Thanks Matthew,
As these are more clarifications, I will incorporate this email into the approved documents for the record. So the stamped set is all we need to move forward with this approval.

1 - I made a slight typo in that eMail. The updated "code" information attached was the updated Ground Floor Life Safety Plan (LS101) not the typed code analysis document, sorry for that confusion.

10 Third Floor Life Safety Plan

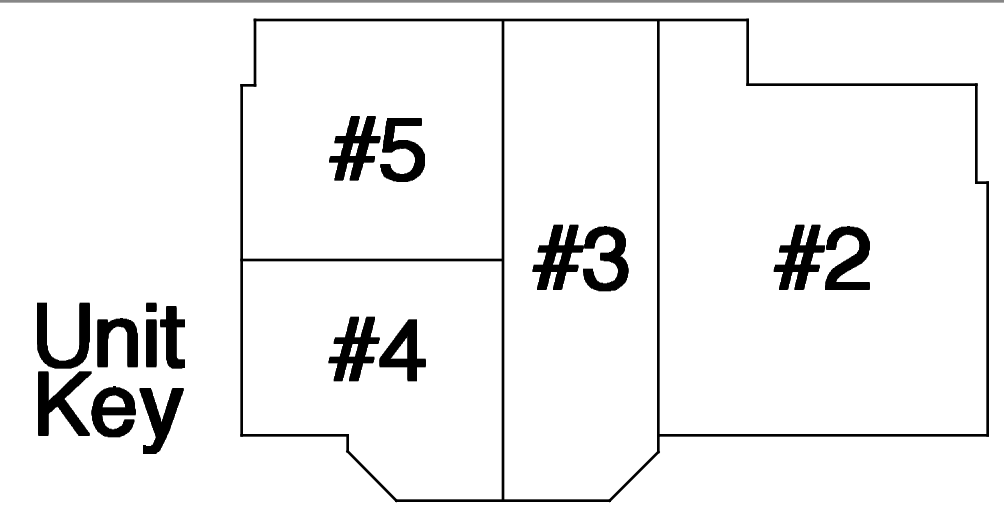
You had two questions on LS103. Both were inside Bedroom #302. Yes it is an egress window and the door

leads into a closet under the sloping roof in that corner of the building.
